# Rezoning Transportation Analysis

Petition Number: 2020-137

General Location Identifier: Tax ID 04922121

Date	Description
10-26-20	First Review
11-30-20	Second Review
12-28-20	Third Review

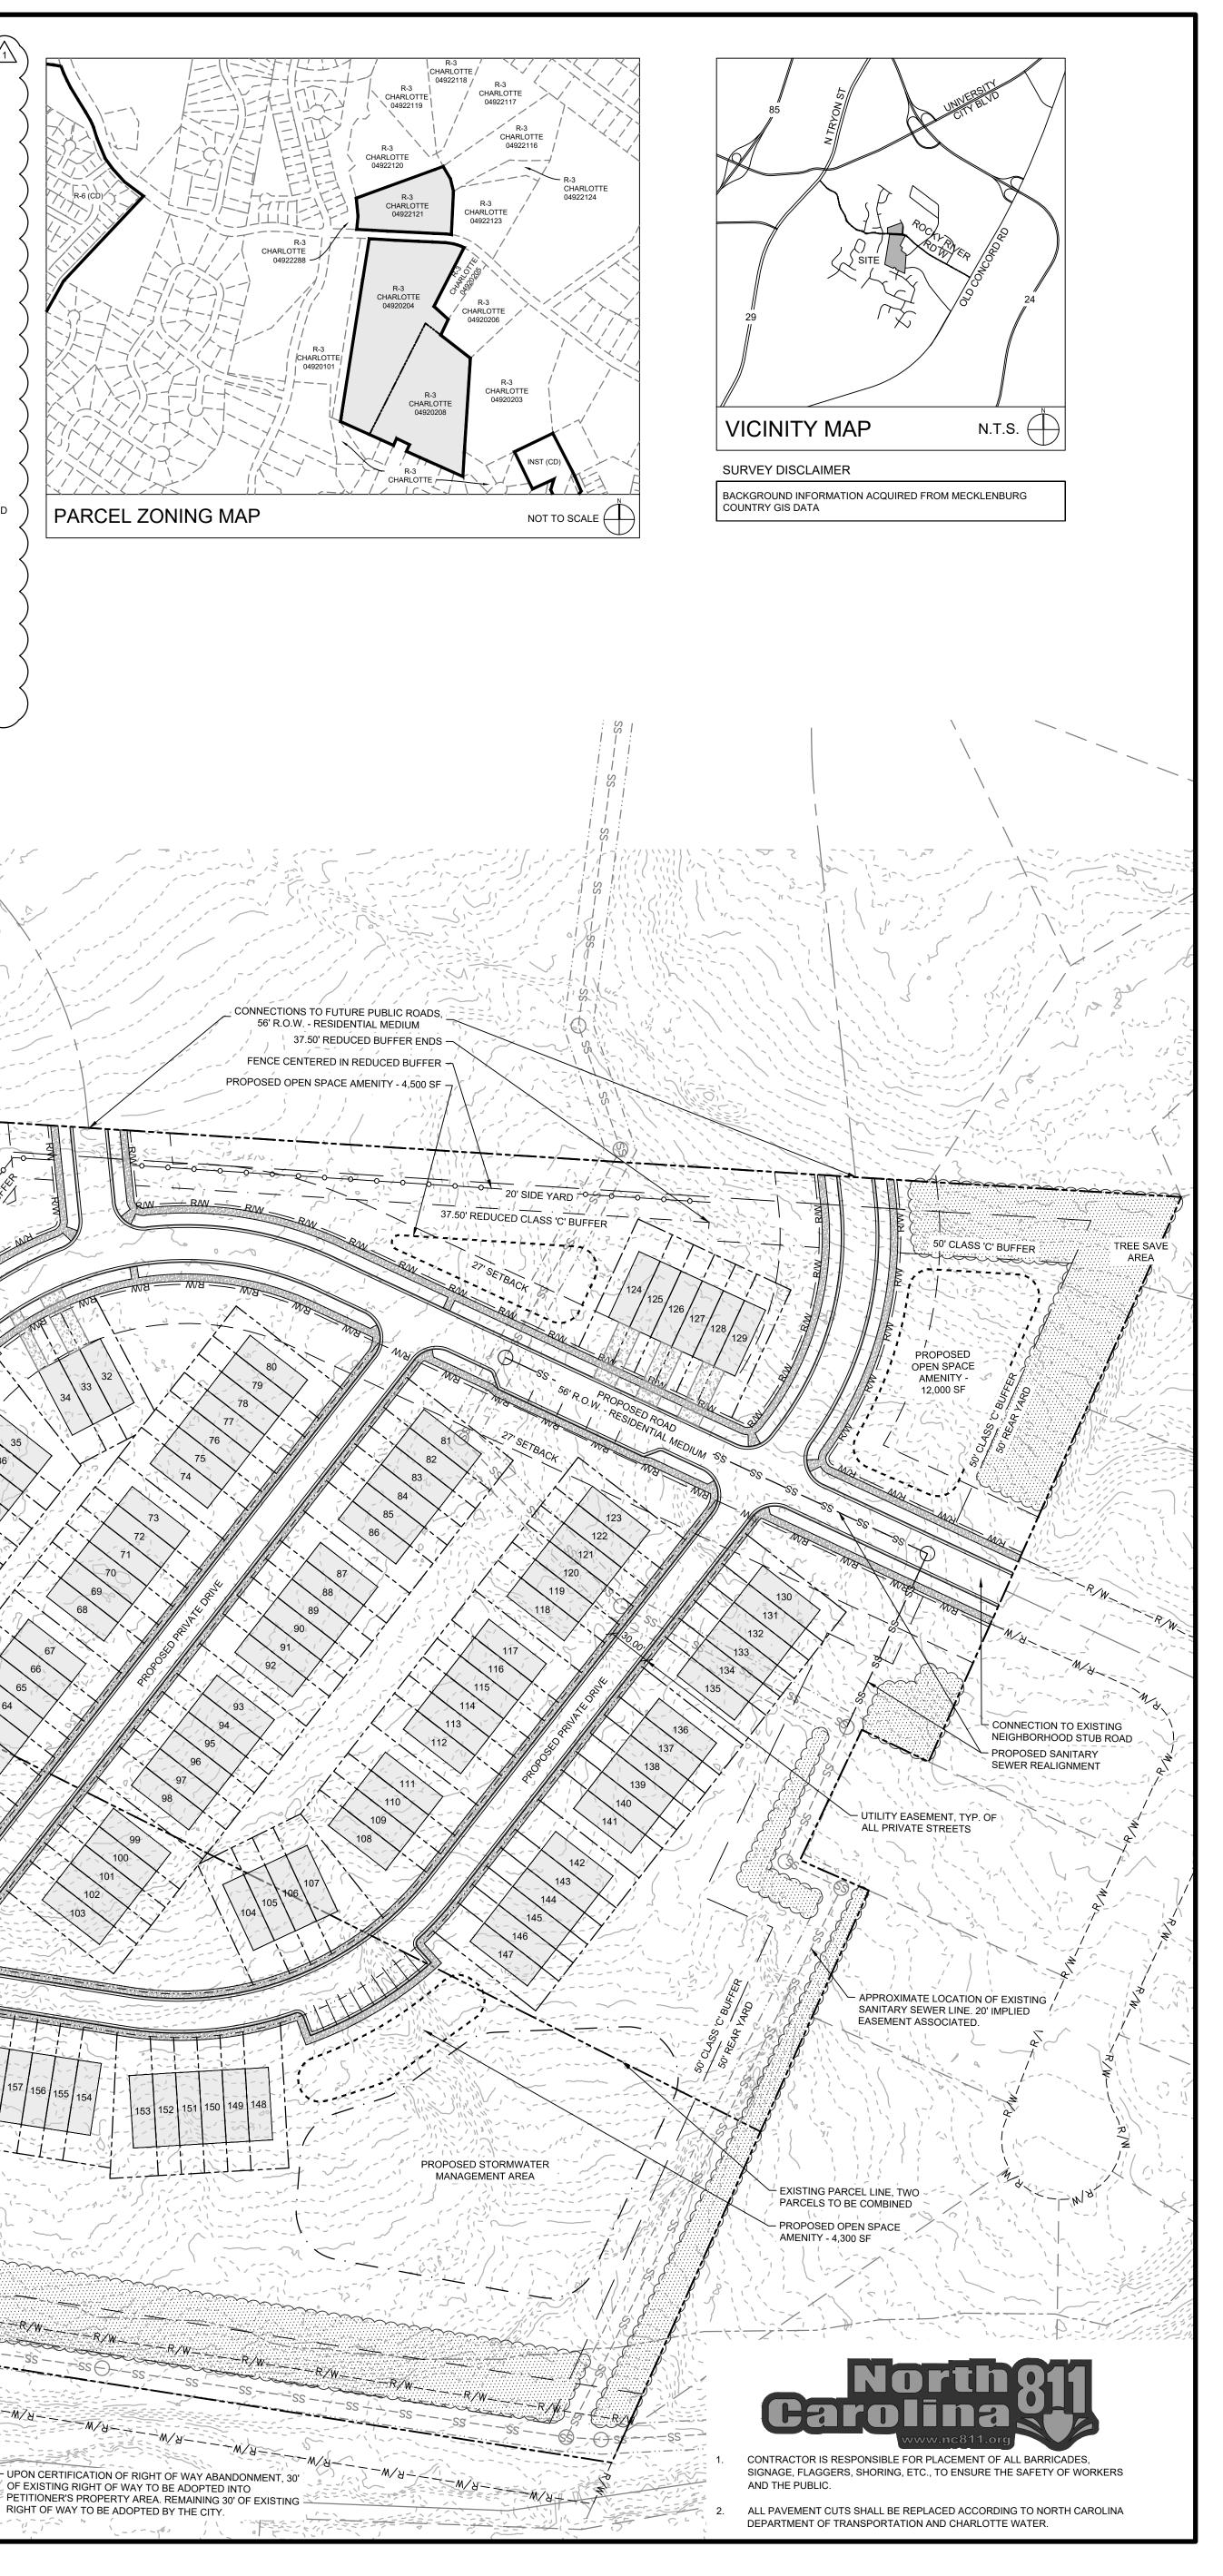
Revise the site plan and conditional note(s) to commit to dedicate connecting the northern development to Newell View Lane while providing a hammerhead at the western limits, reducing conflict points at the Rocky River Road West Intersection.

8. Revise the site plan and conditional note(s) to commit to providing a left turn lane into the development as required for developments that generate over 500 trips per day.

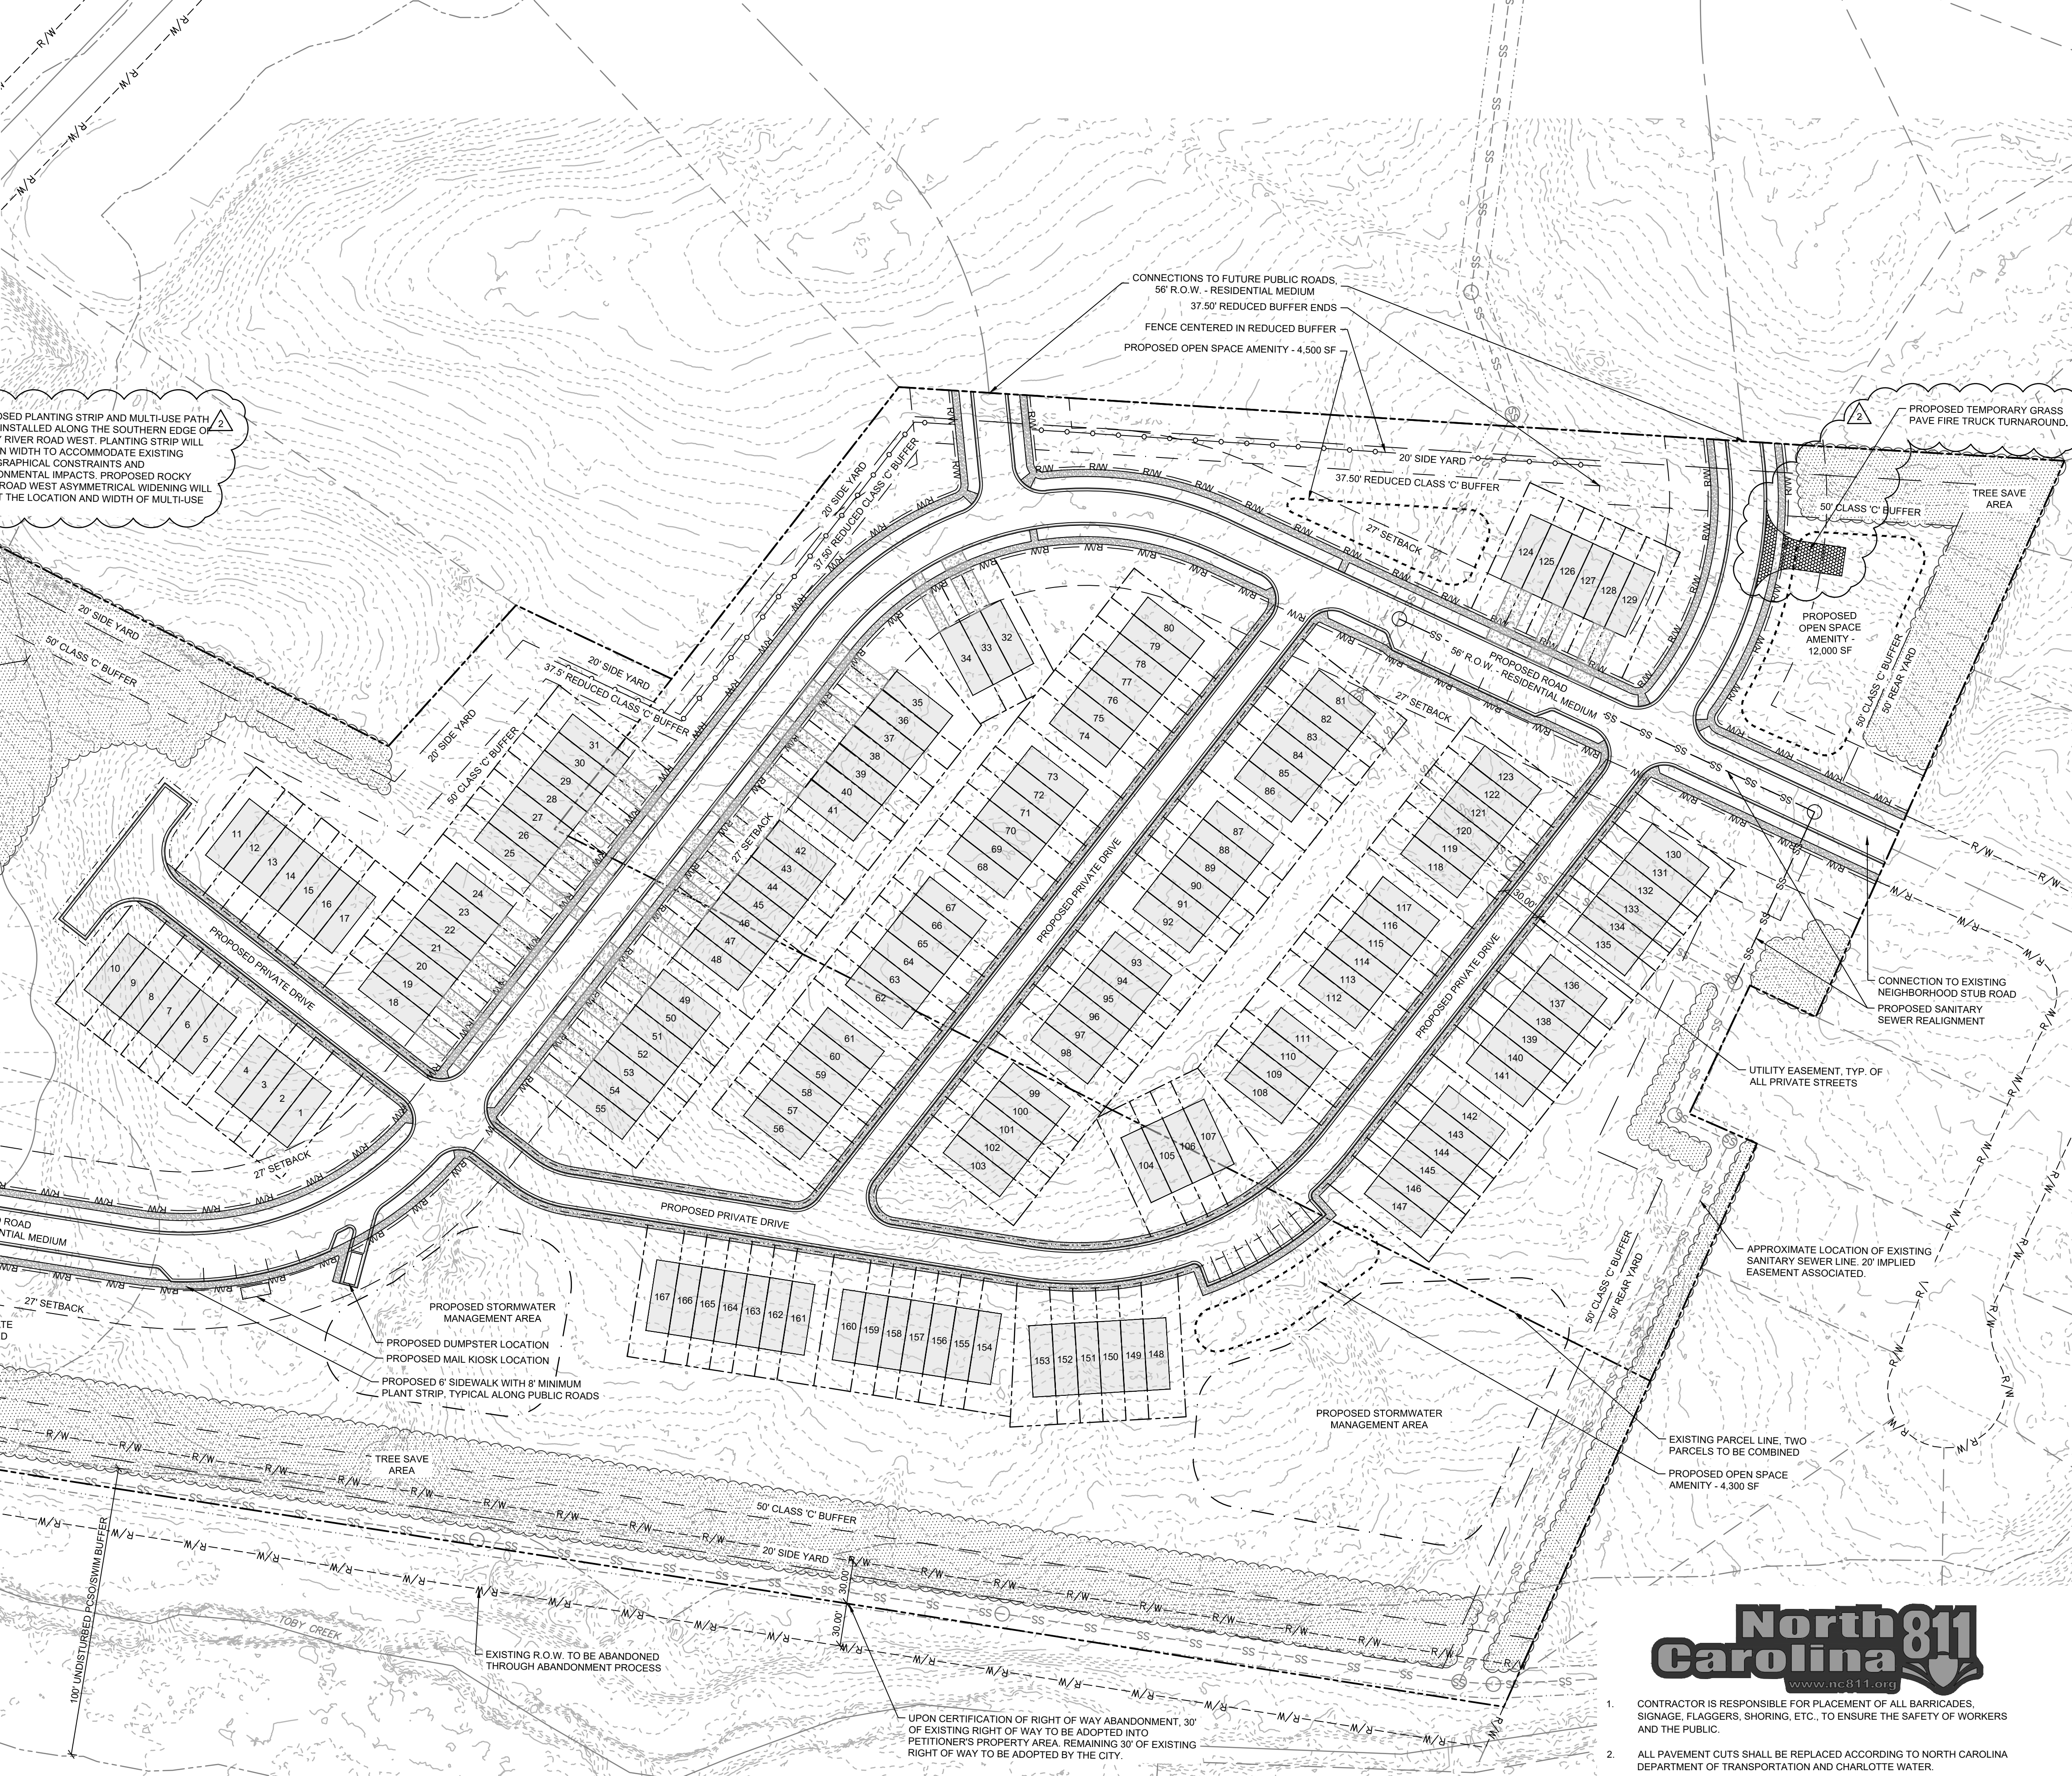
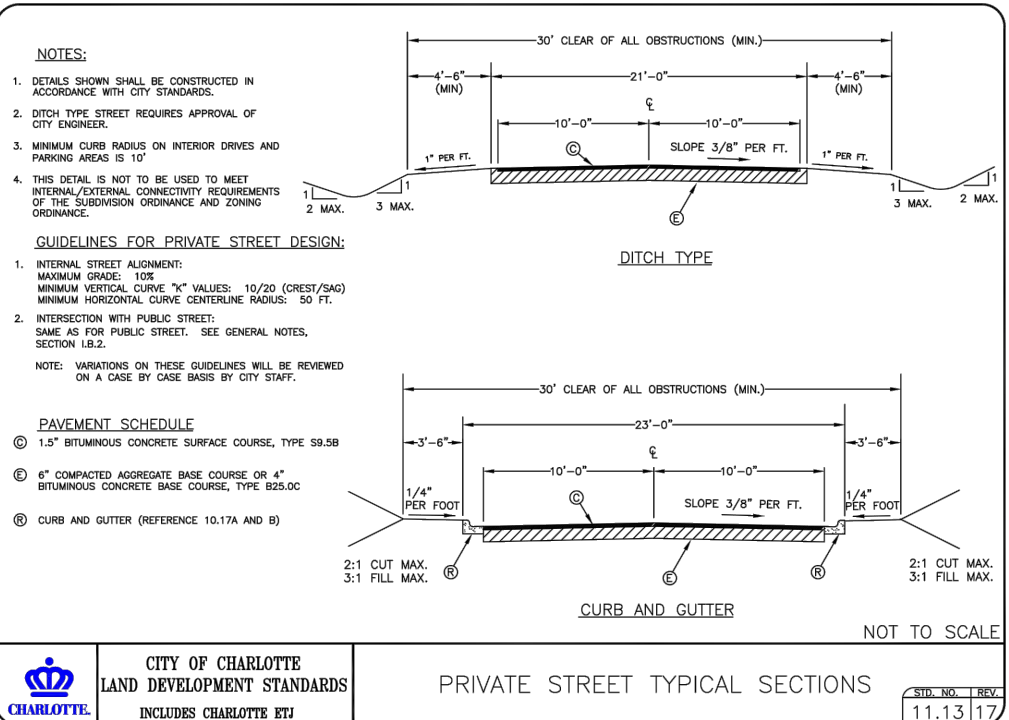
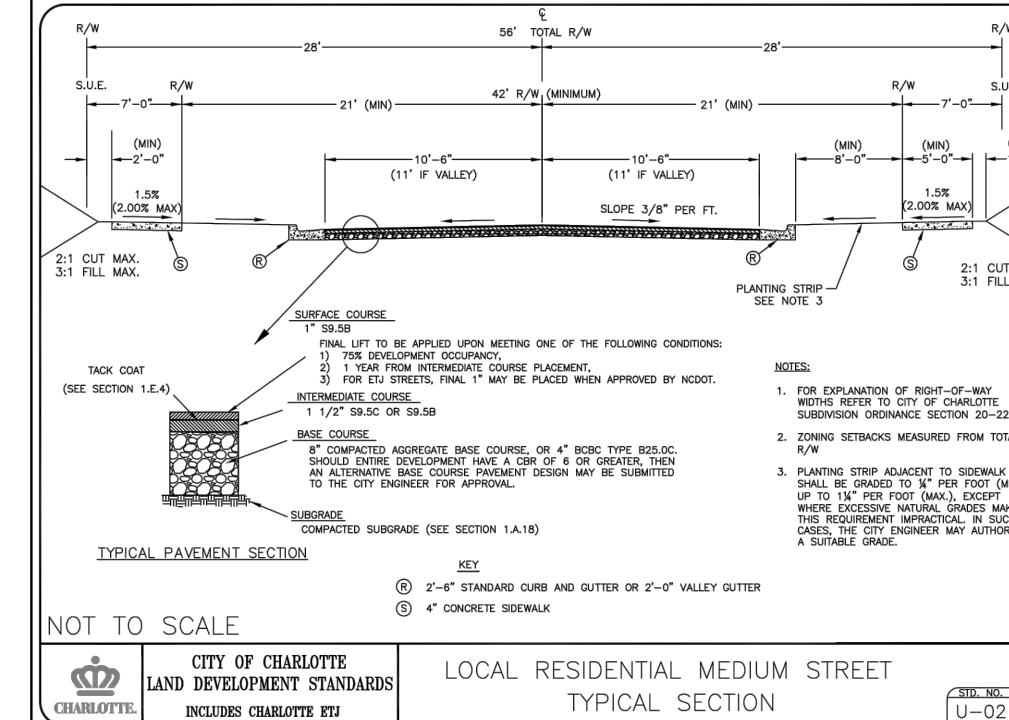
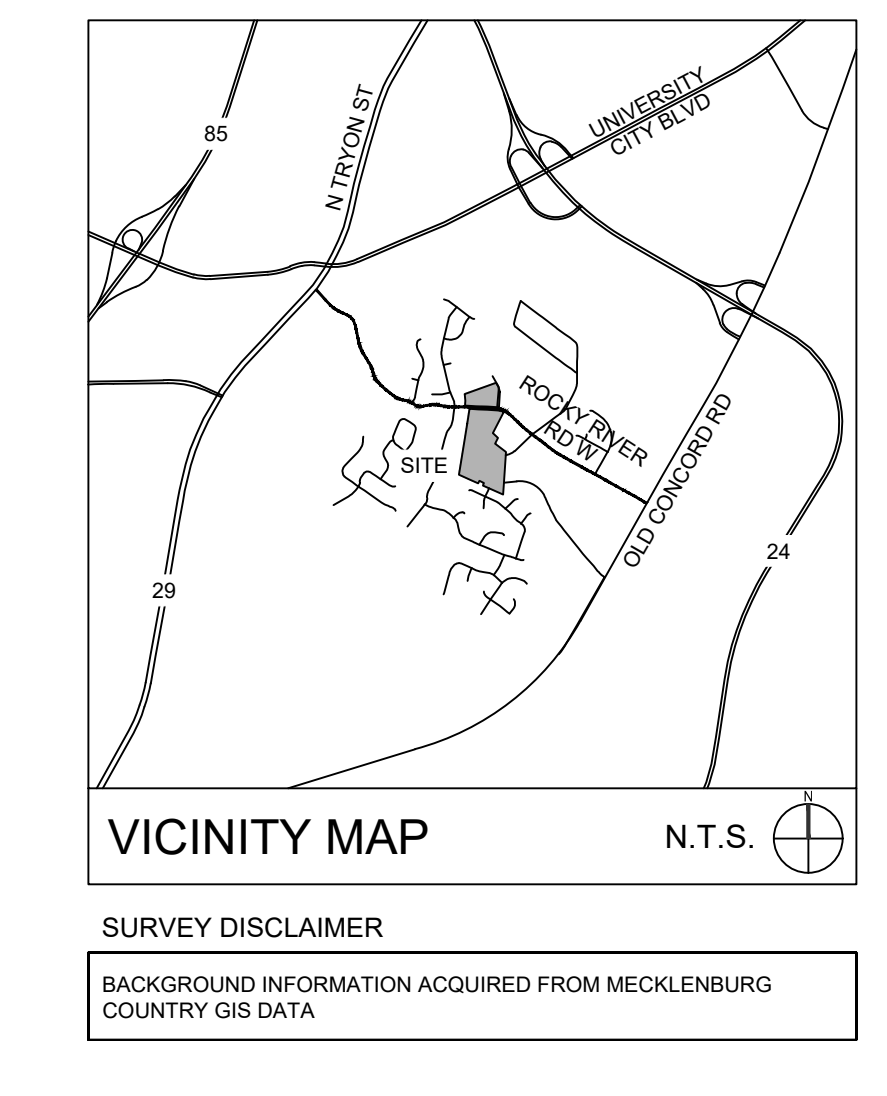
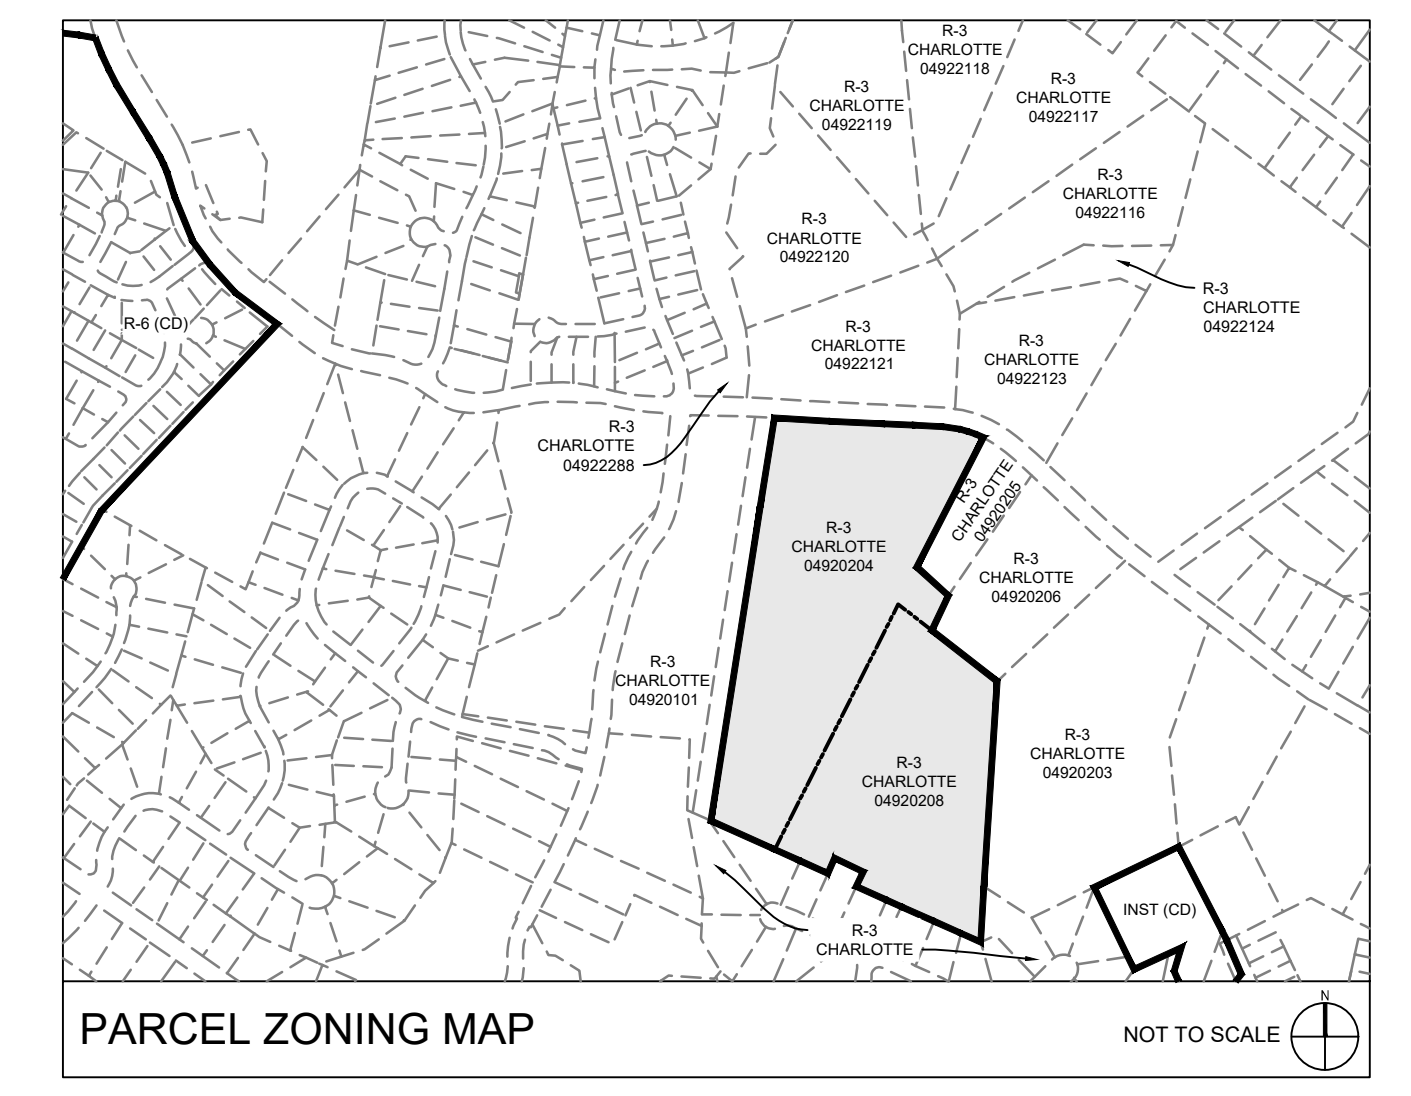
Revise the site plan and conditional note(s) to commit to installing a 12' multi-use path (MUP) along property frontage with pedestrian structure(s) or culvert extension to provide connectivity and accessibility in accordance with the City of Charlotte BIKE and Charlotte WALKS policies. Rocky River Road West is a designated Overland Connector on the Greenway Master Plan.
